Re: QuikTrip 7001, Albuquerque
Matkin Hoover Job No. 7001.01

TCL No. K10D070

This letter and its attachments serve as a response to comments received on May 16th, 2024, concerning the above referenced project.

SHEET NUMBER:
C100
05 OF 25

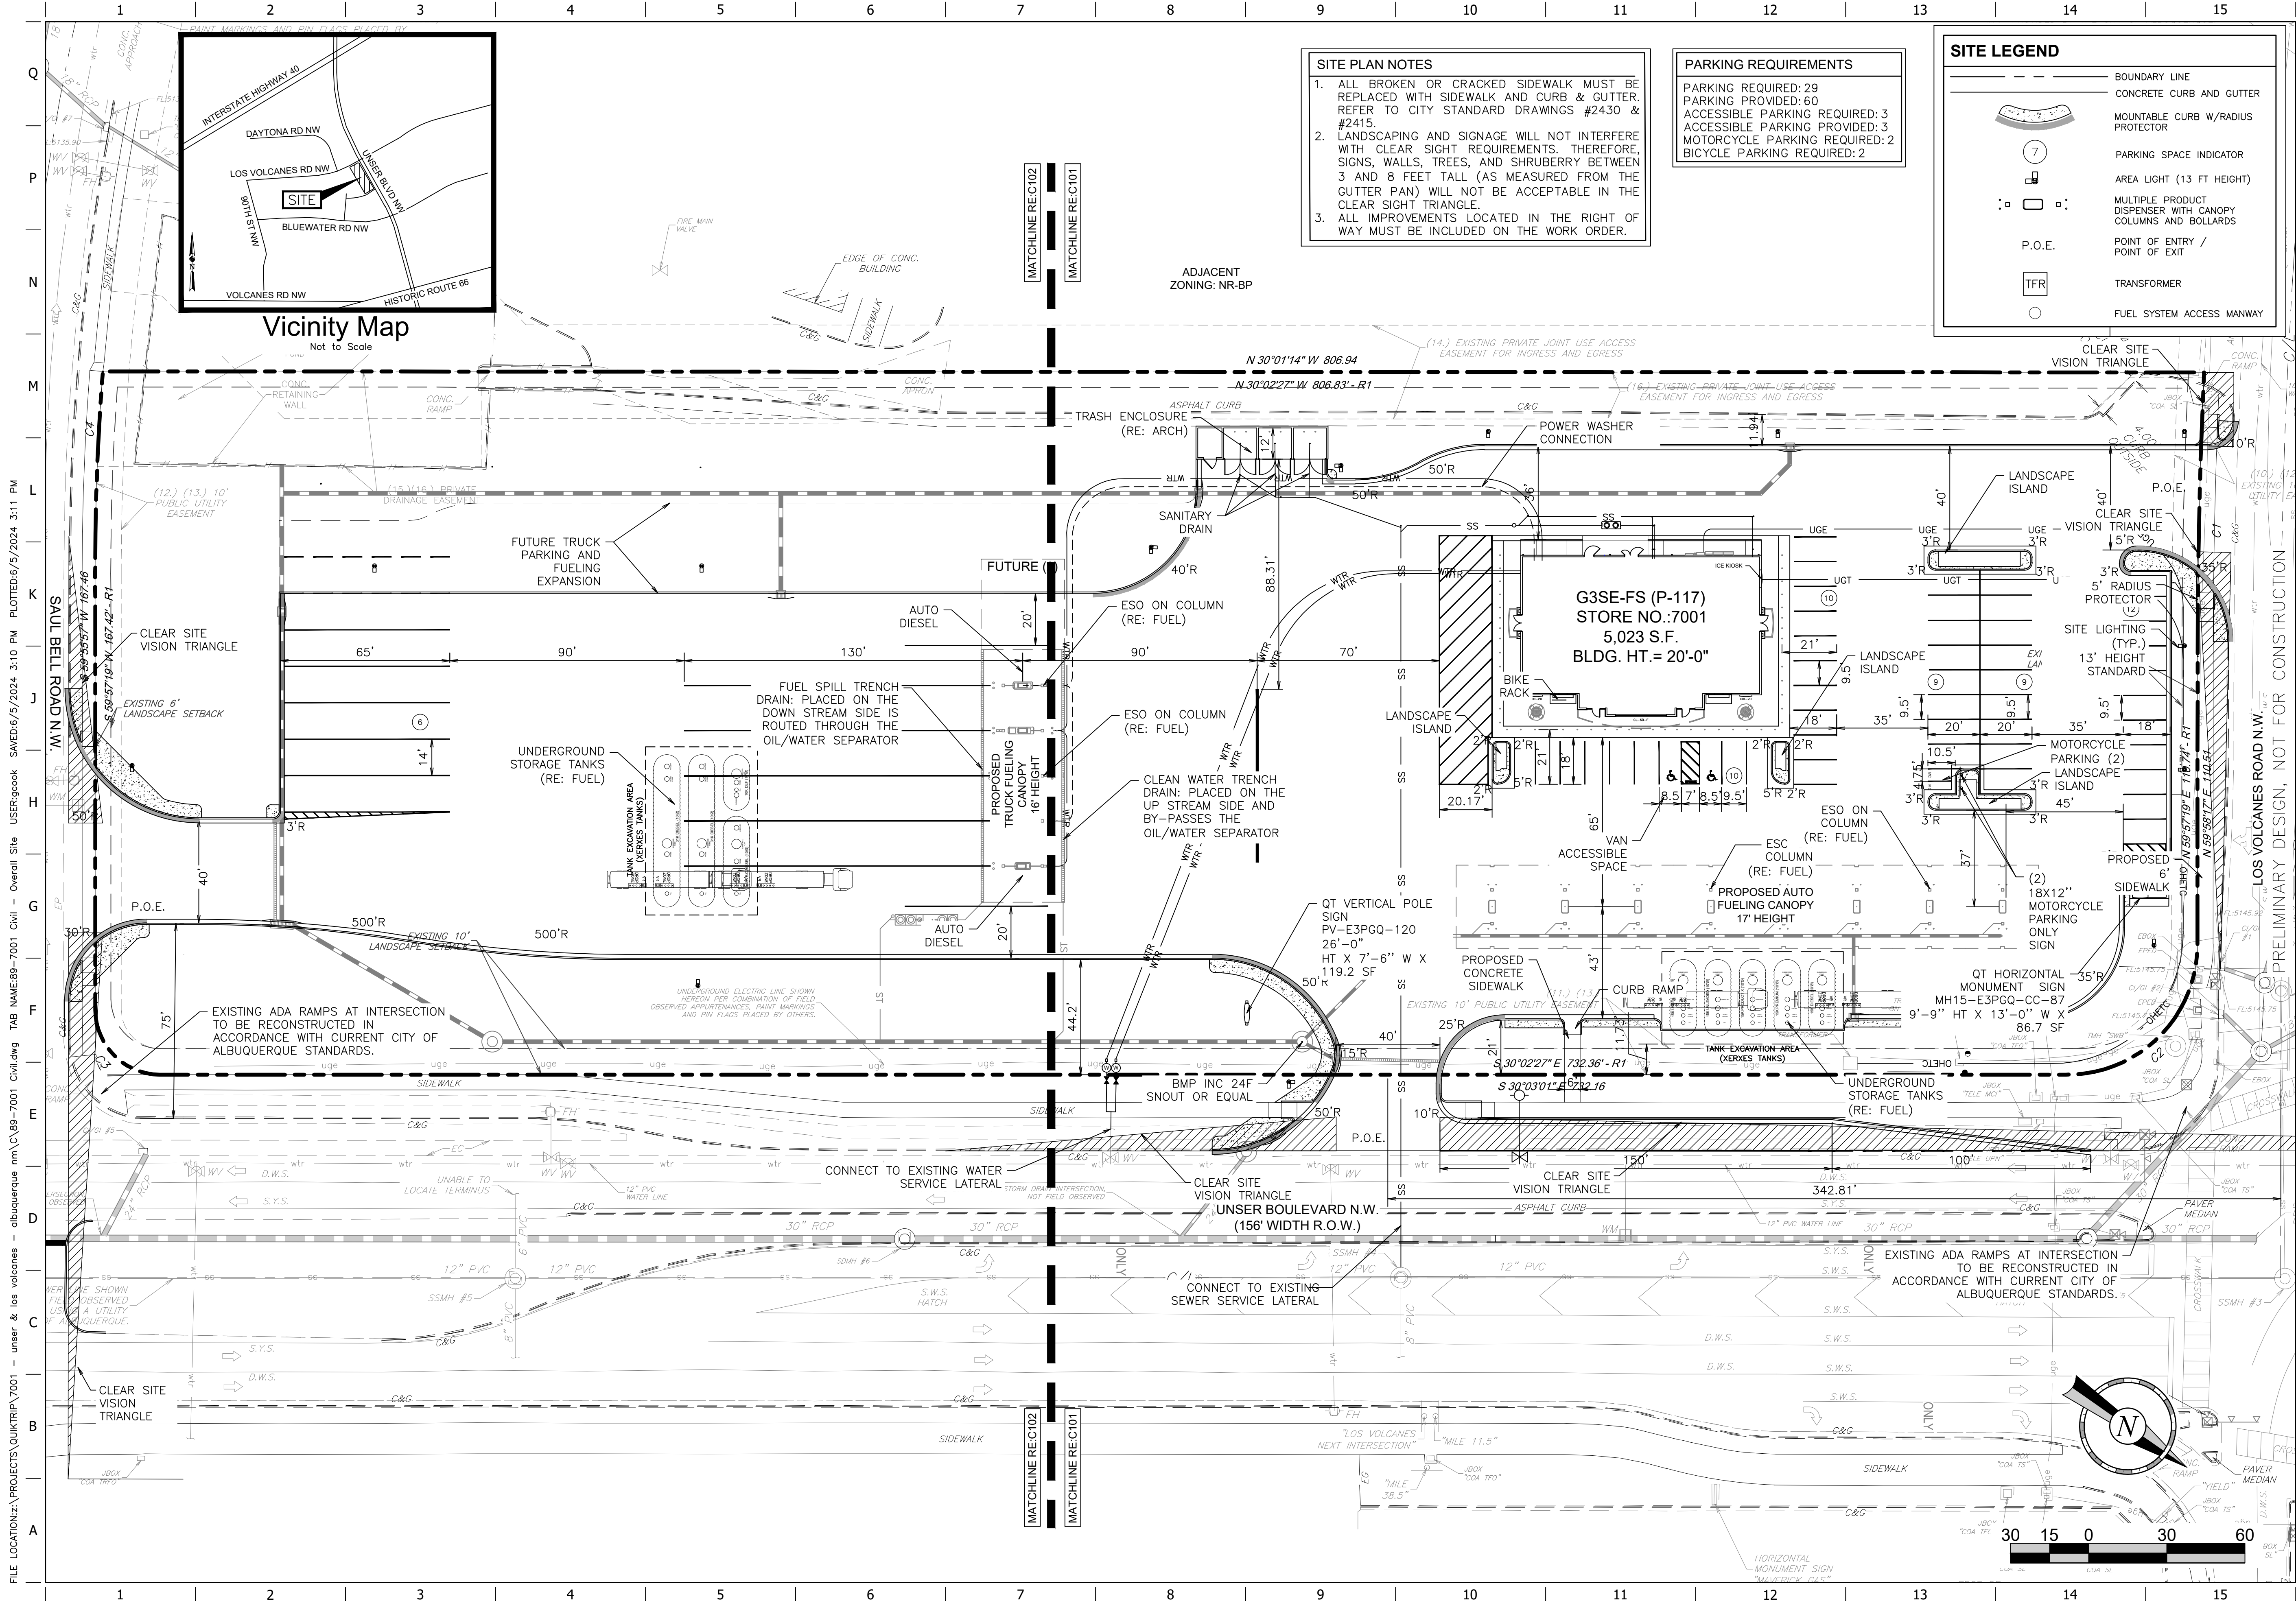
List the number of Motorcycle and Bicycle parking spaces required by the IDO.

The minimum distance from the intersection to site access off Saul Bell Rd. is 75 ft. please show this dimension on the site plan.

Motorcycle parking spaces shall be designated by its own conspicuously posted upright sign, either free-standing or wall mounted per the zoning code.

The pavement marking “MC” should be shown in the opposite direction for motorcycles entering the parking space.

Add the following note to the plan: “Landscaping and signage will not interfere with clear sight requirements. Therefore, signs, walls, trees, and shrubbery between 3 and 8 feet tall (as measured from the gutter pan) will not be acceptable in the clear sight triangle.

Please add a note on the plan stating “All improvements located in the Right of Way must be included on the work order.”

Add a note stating “All broken or cracked sidewalk must be replaced with sidewalk and curb & gutter.” A build note must be provided referring to the appropriate City Standard drawing (2430, 2415A and 2415B).

Concur. Minimum motorcycle and bicycle requirement added to parking requirements on sheet C100 according to City of Albuquerque Part 3: General Regulations Section 14-16-3-1: Off-Street Parking Regulations.

Concur. Requested Driveway shifted plan north to accommodate 75ft clearance.

Callout added to site plan implementing a 18x12” motorcycle parking only sign.

Pavement marking “MC” added to plans in motorcycle parking area.

Note added to Overall Site Plan as requested.

Note added to Site Plan under “Site Plan Notes”

Concur. Note added to Site Plan Notes referencing City Standard Details #2430, 2415A and 2415B.

SHEET NUMBER:
C113
13 OF 25

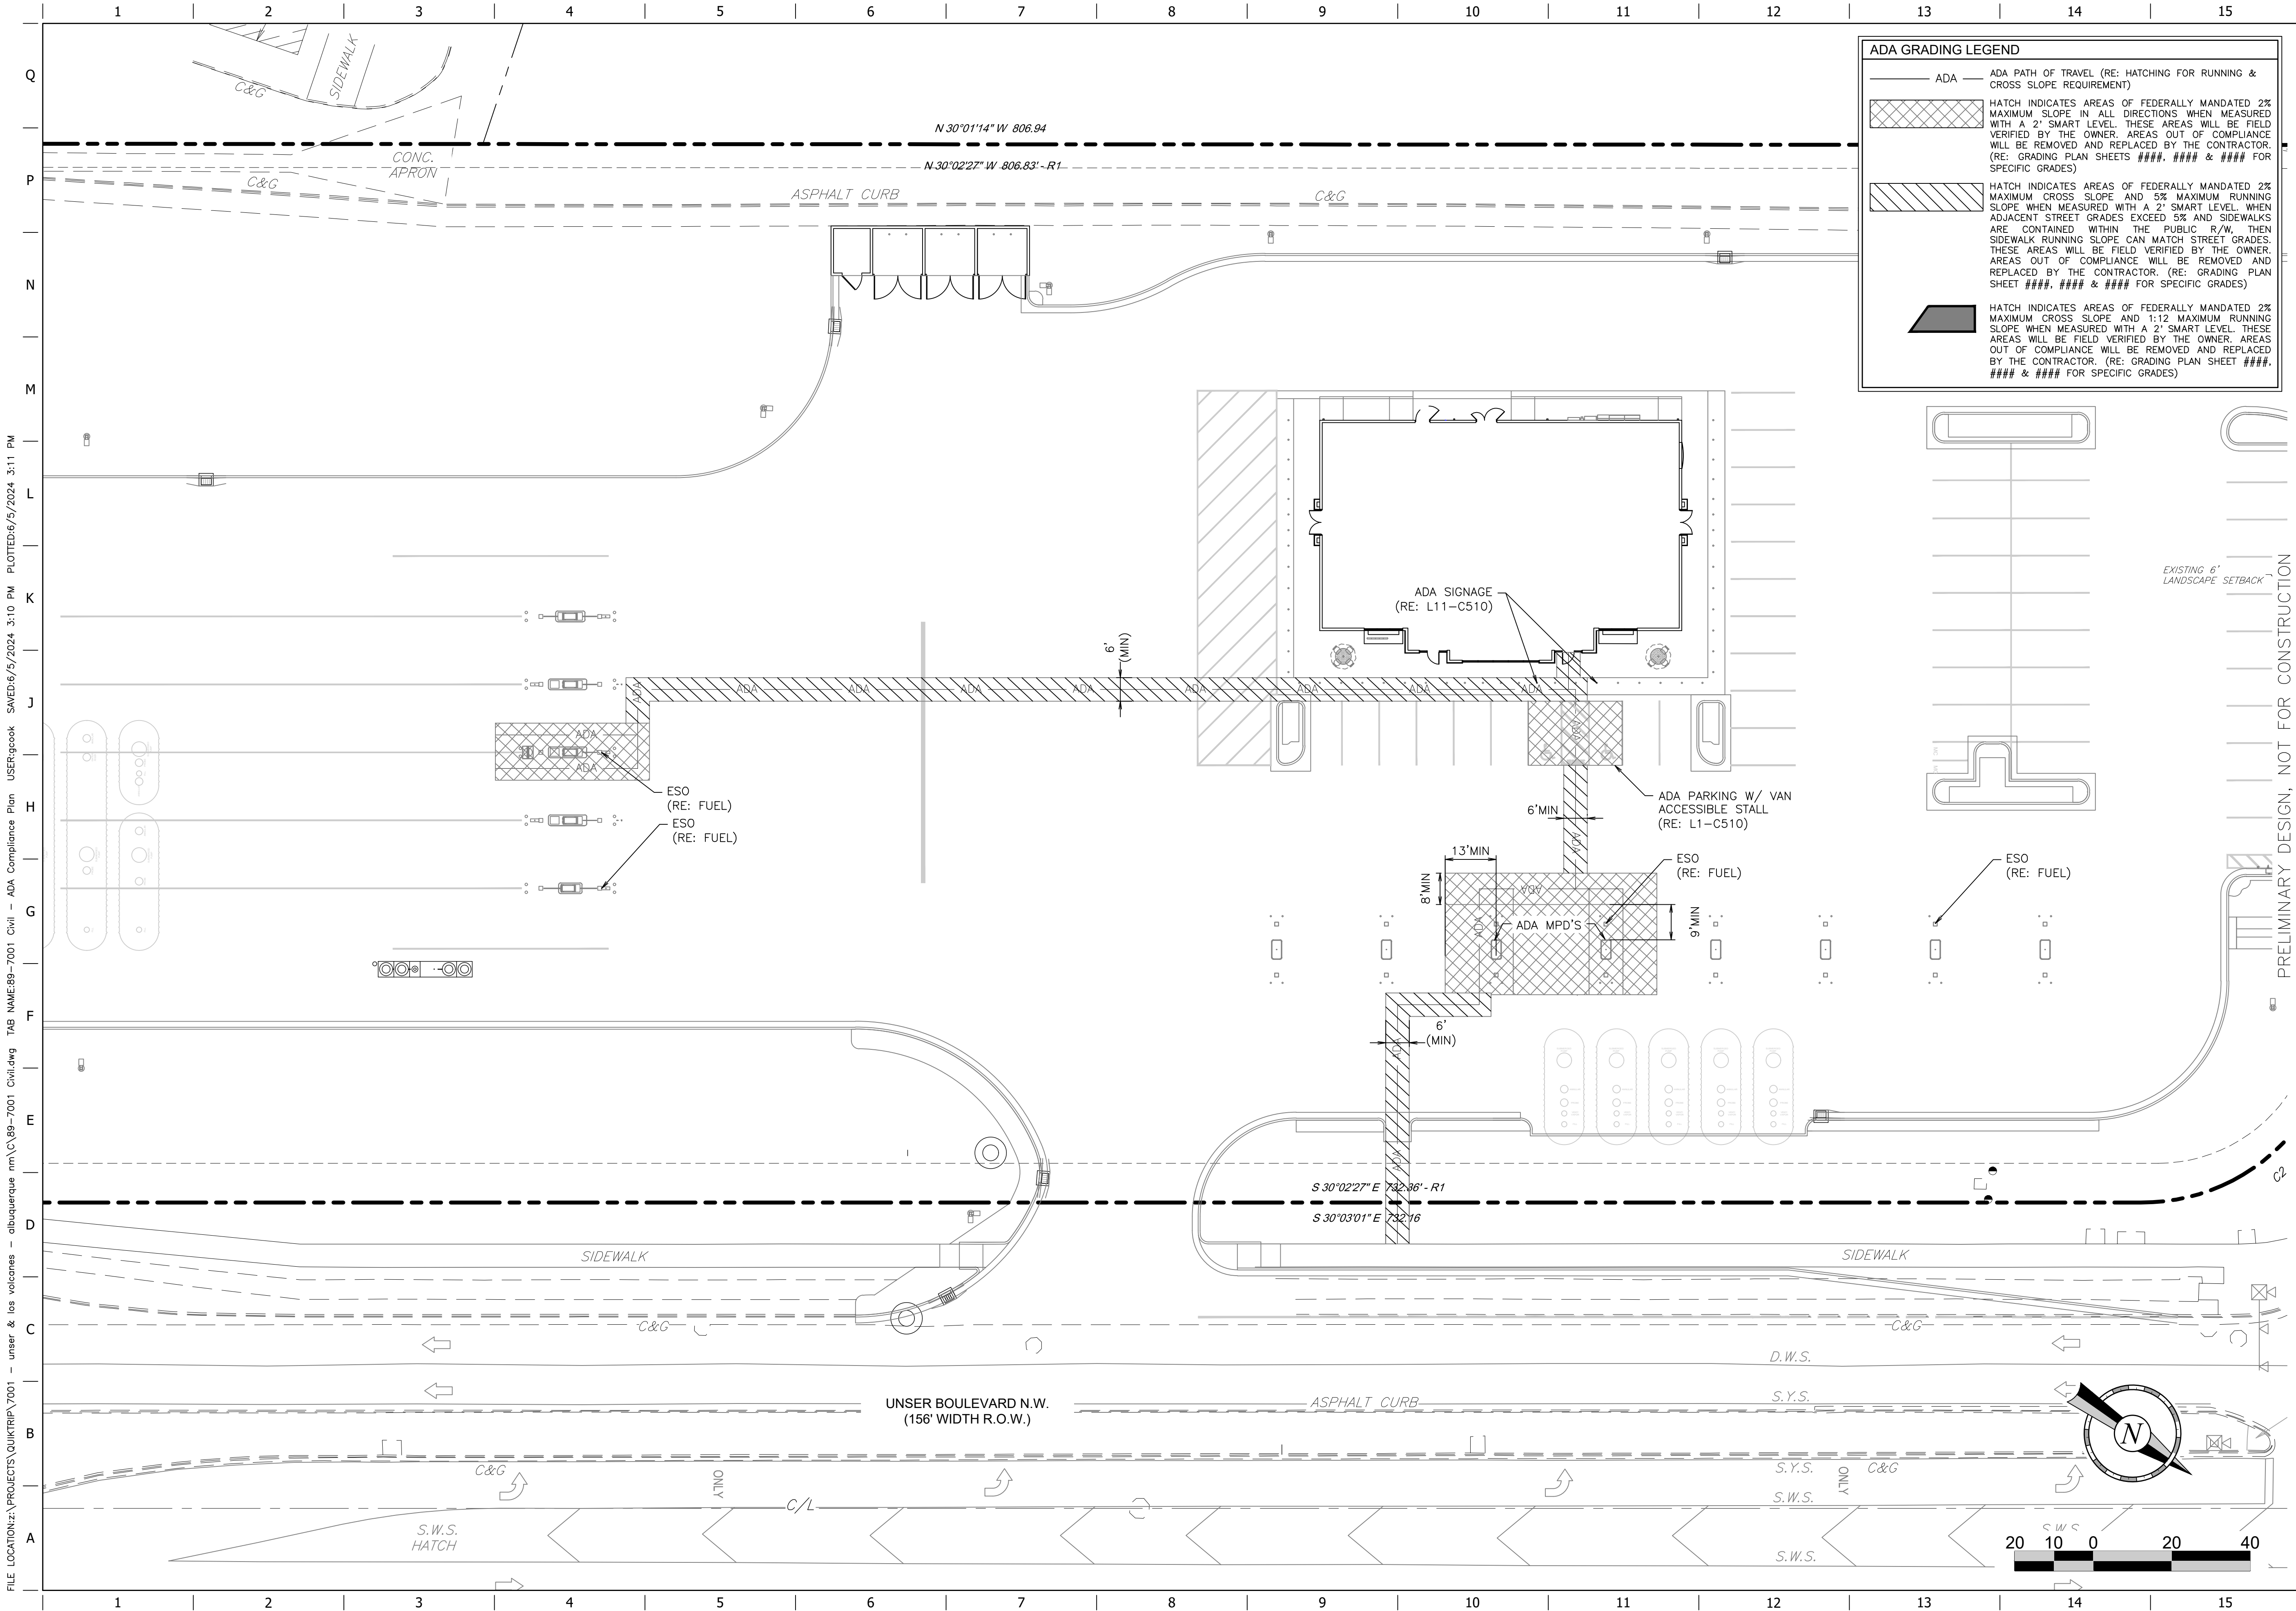
Per the IDO, a 6 ft. wide ADA accessible pedestrian pathway is required from the public sidewalk to the building entrances. Please clearly show this pathway and provide details.

Per DPM, a 6 ft. wide ADA accessible pedestrian pathway is required from the ADA parking stall access aisles to the building entrances. Please clearly show this pathway and provide details.

ADA accessible pedestrian pathway should not be placed behind parking space or adjacent to a vehicular way. Vehicle and pedestrian/wheel chair conflicts should be avoided as much as possible.

Concur. A 6' ADA pathway has been designed to fulfill the requirements listed. ADA Compliance Plan sheet added to plan set for reference, containing full ADA path.

Concur. A 6' ADA pathway has been designed to fulfill the requirements listed. ADA Compliance Plan sheet added to plan set for reference, containing full ADA path.

Concur. A 6' ADA pathway has been designed to fulfill the requirements listed. ADA Compliance Plan sheet added to plan set for reference, containing full ADA path.
